24 September 2013

Ref: R/190/13/1 – OBJECTION - Land to the rear of 20 & 22 Broadmark Lane, Rustington, West Sussex

PROPOSED STREET (SOUTH) ELEVATION (1:200)

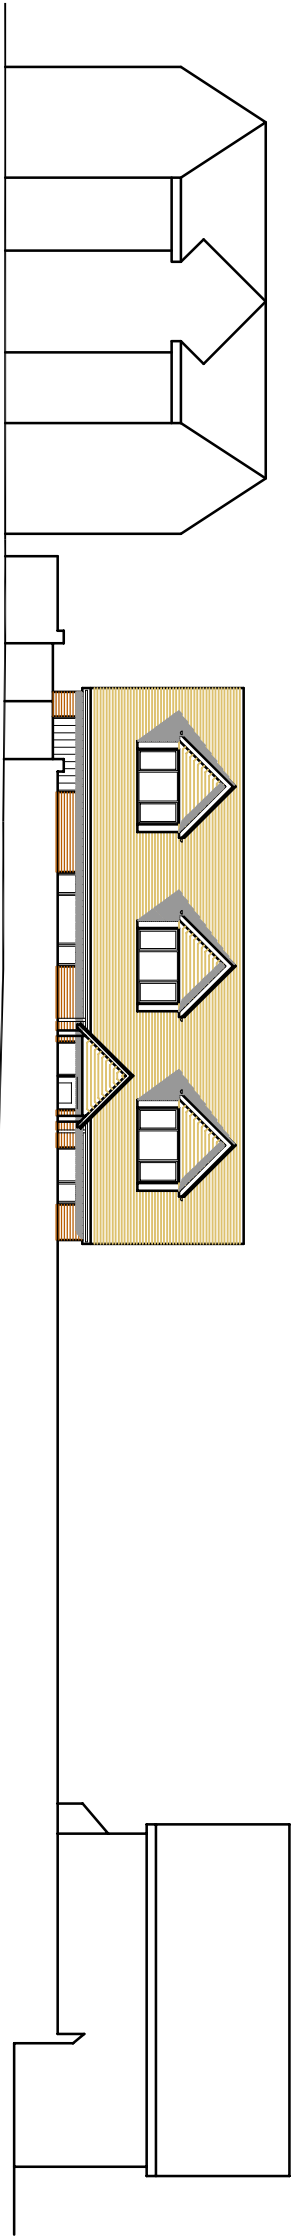
The proposed build will definitely affect the existing outlook and seriously overshadow No 4 Broadmark Way. A two storey building will cause serious over shadow to all of the adjacent properties and gardens especially when the sun is in the south and west by blocking natural daylight.

The proposed building will be far too close to the boundary fences of No's 22 & 20 Broadmark Lane and 4 Broadmark Way.

DRAWING TITLE
PROPOSED FLOOR PLANS & ROOF PLAN

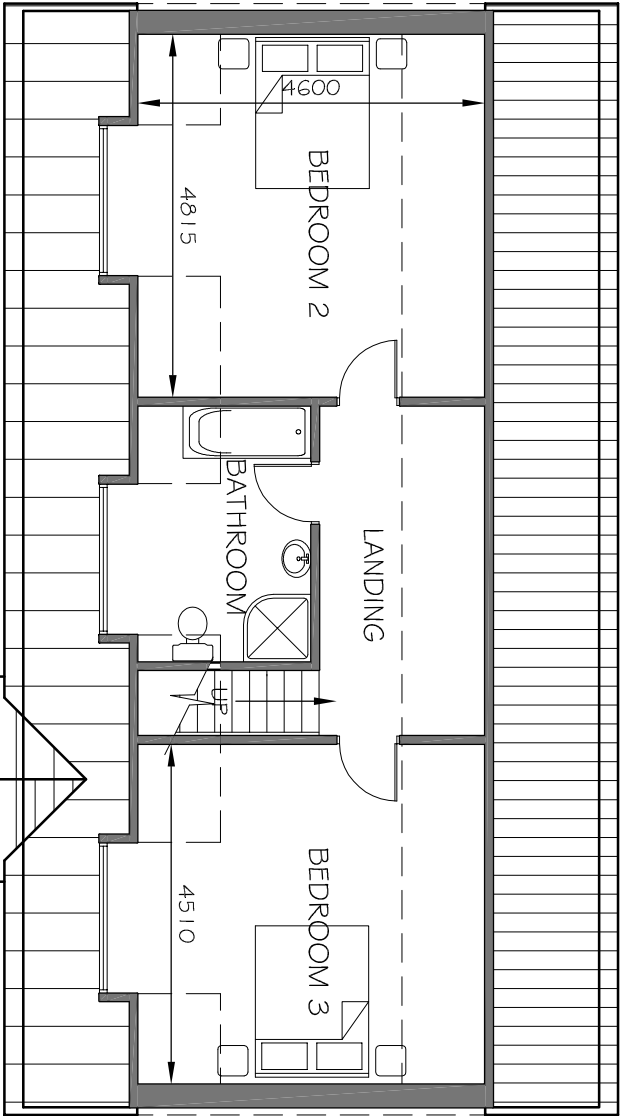
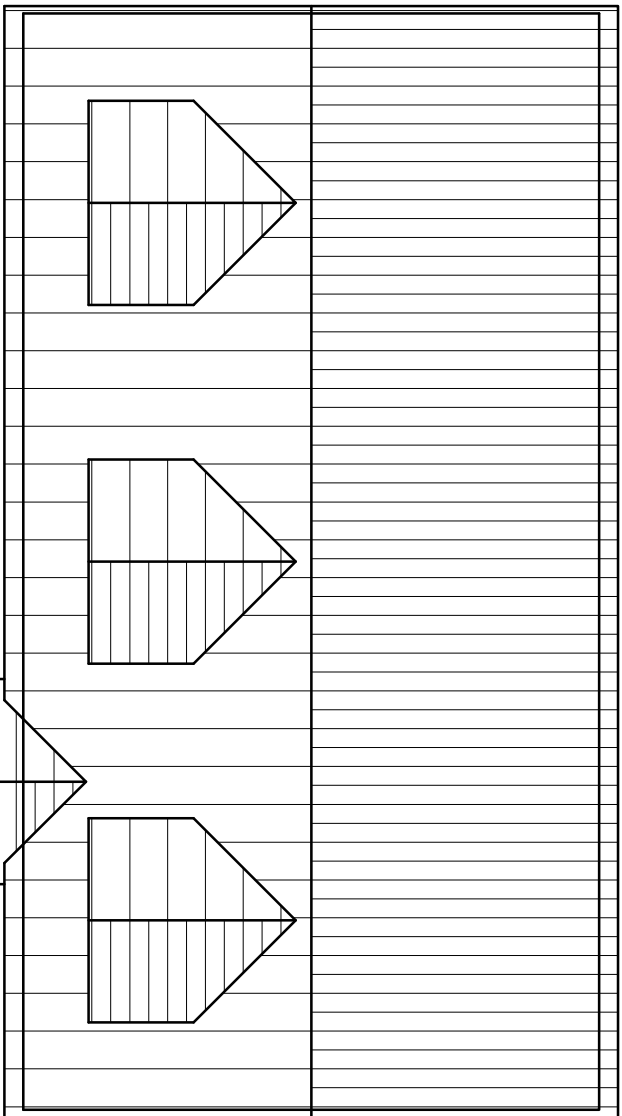
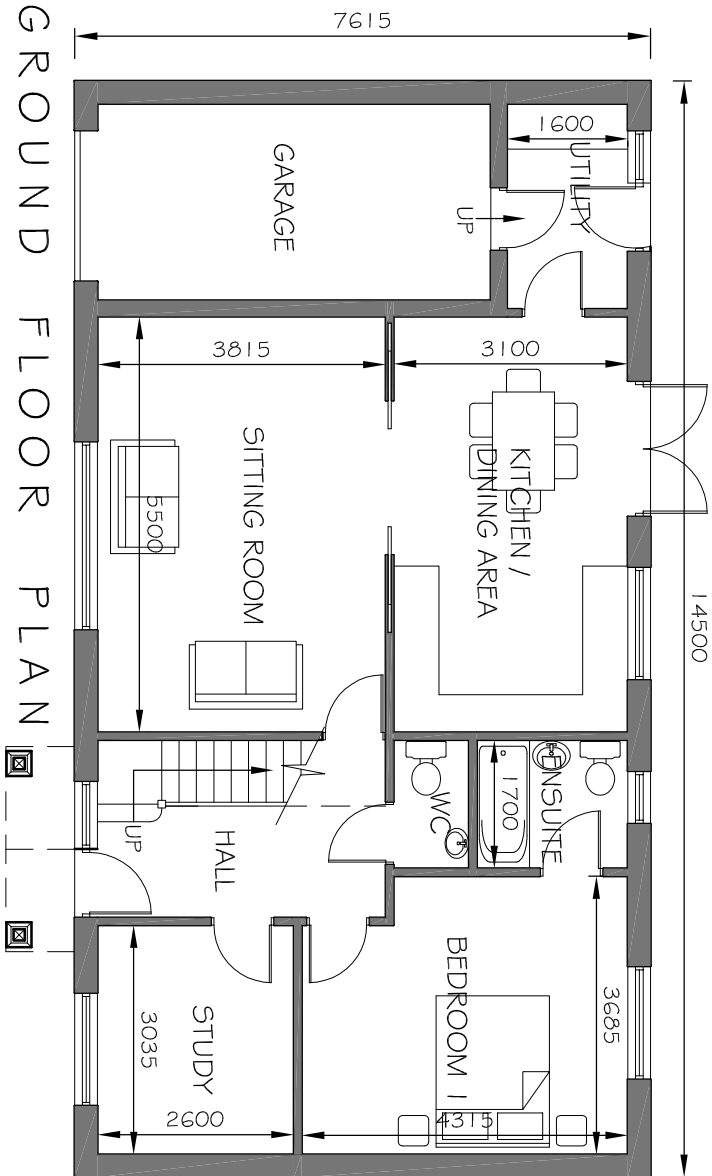
Despite their protestations that this won't be done there will be nothing to stop the owner of this proposed building putting velux and/or dormer windows into the roof at the rear of the building at a later date due to the lack of windows and subsequent lack of natural daylight on the first floor.

DRAWING TITLE
SITE LOCATION AND LAYOUT PLANS

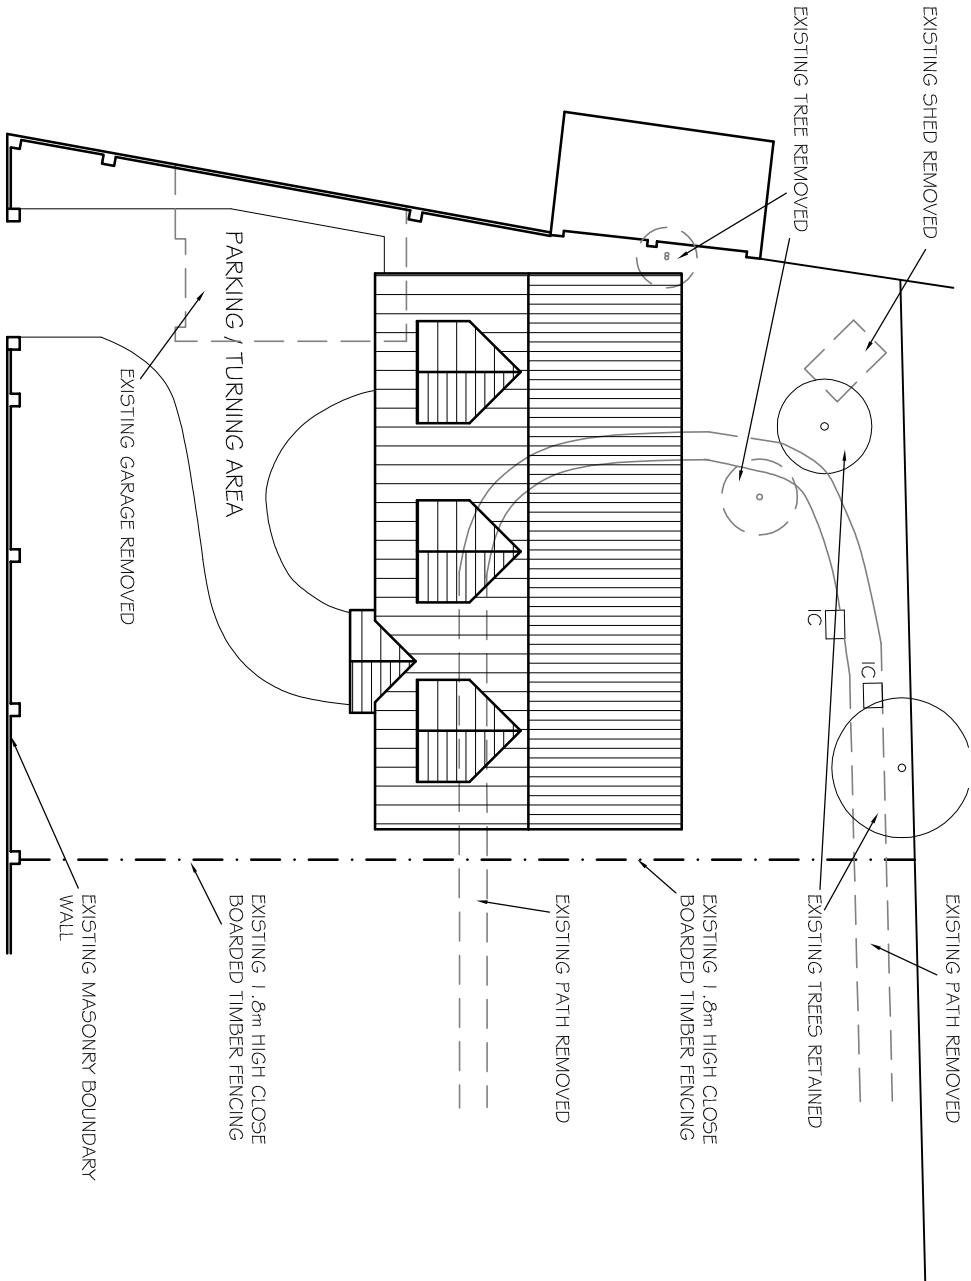
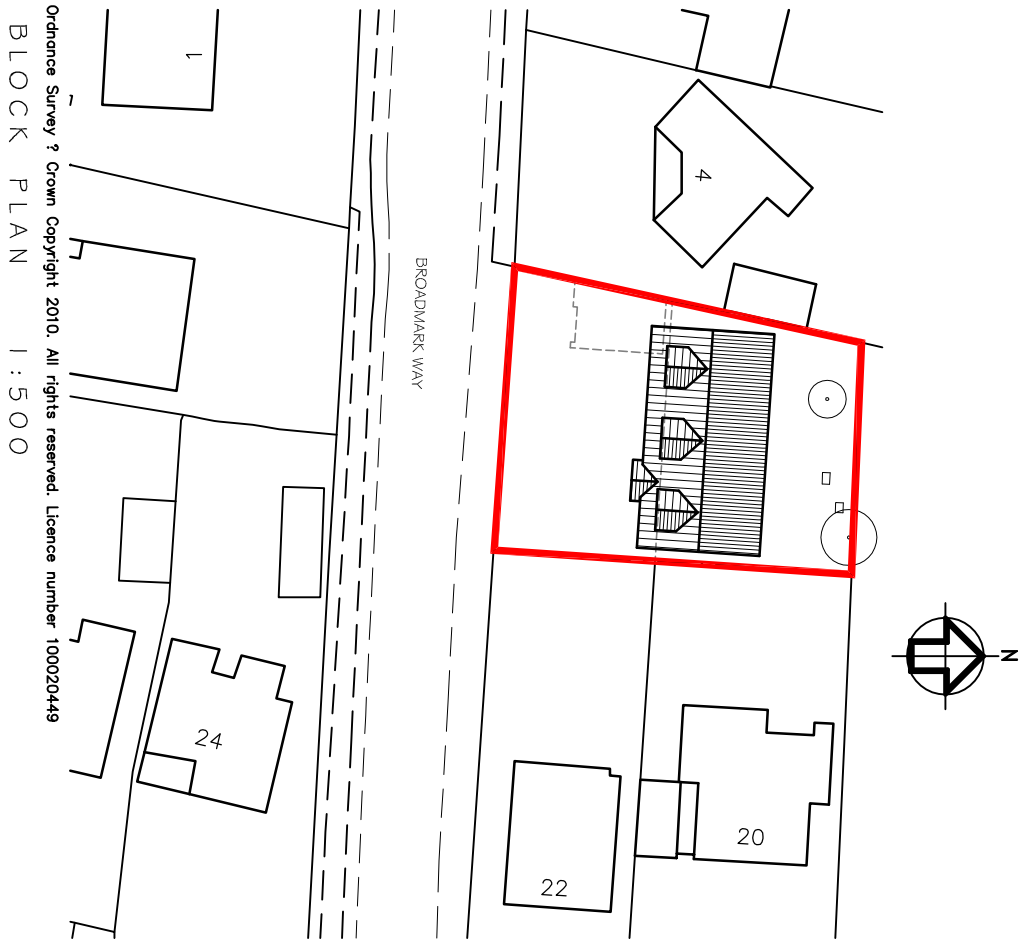
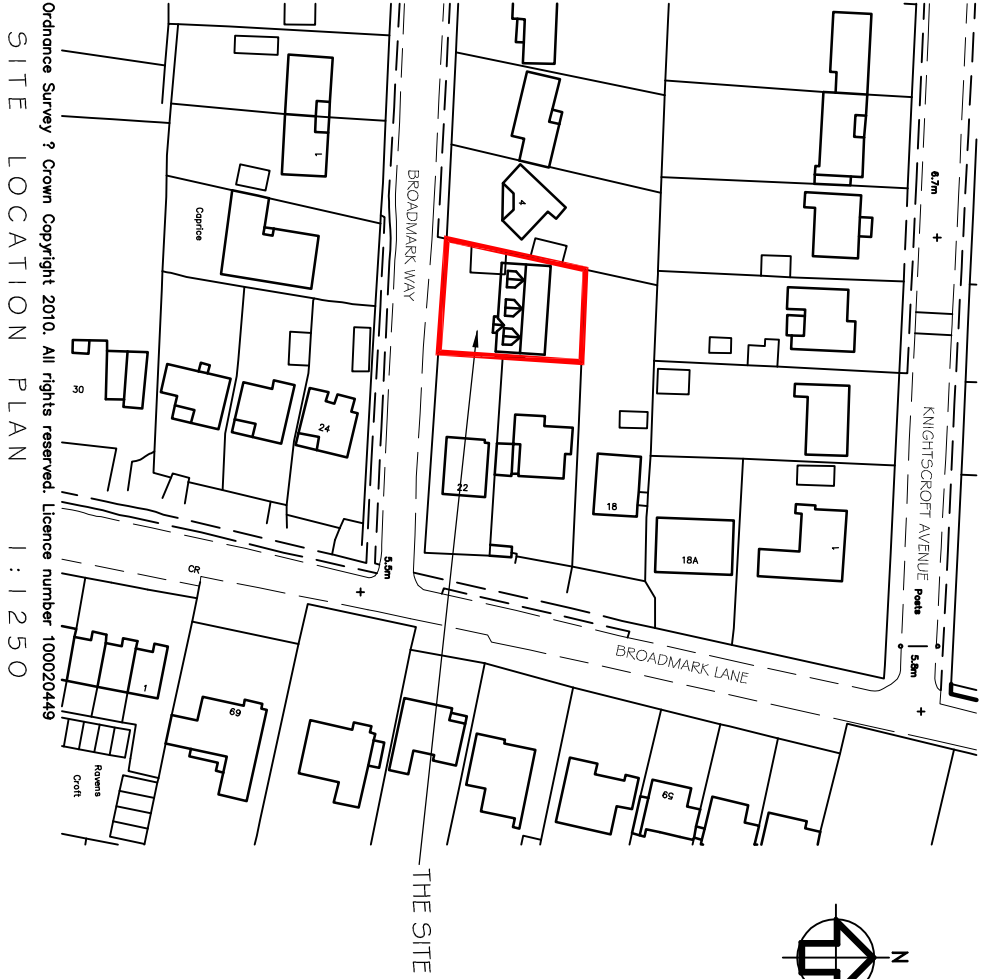
Not enough parking spaces have been allowed for in a property that could potentially house up to 6 adults and anymore than one vehicle parked on the front standing area of the proposed property will be too close to all the neighbouring property boundaries. Broadmark Way has a very strict no parking policy on the road and this will have an impact on the neighbouring properties.
